**Application** H08-0954-25  
**Location** Riseholme Farm Gosberton Risegate PE11 4ET  
**Proposal** Proposed Detached 4 Bed Dwelling

**Name** Diane Gordon  
**Address** SHDC Environmental Protection

Proposed Block Plan-Landscaping

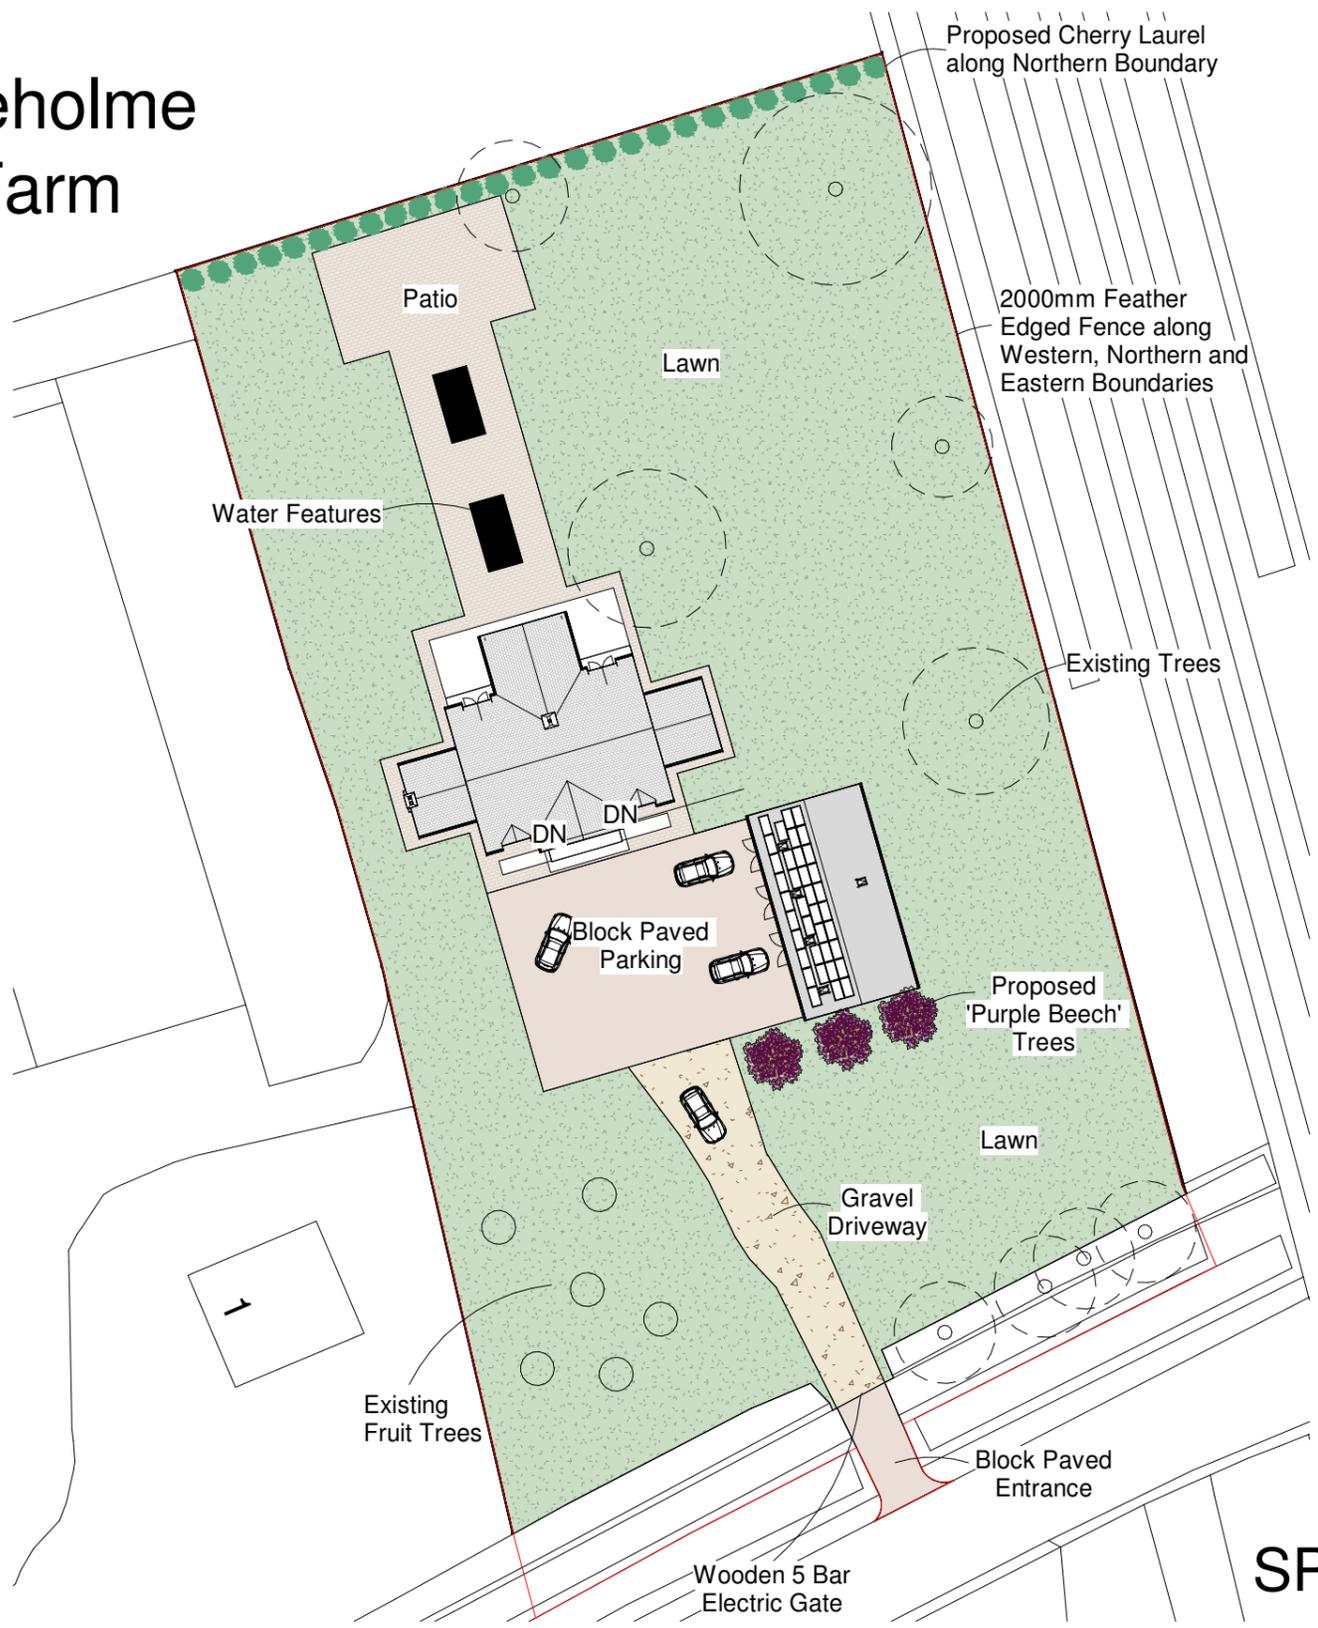
the conclusions of these advise that the proposed 2.5m high full acoustic fencing to the rear boundary is appropriate to achieve sufficient sound reduction . this would ensure that night time levels are attenuated to an appropriate level to meet an acceptable standard of amenity of the occupants. we would therefore support the construction of an appropriate barrier fence.
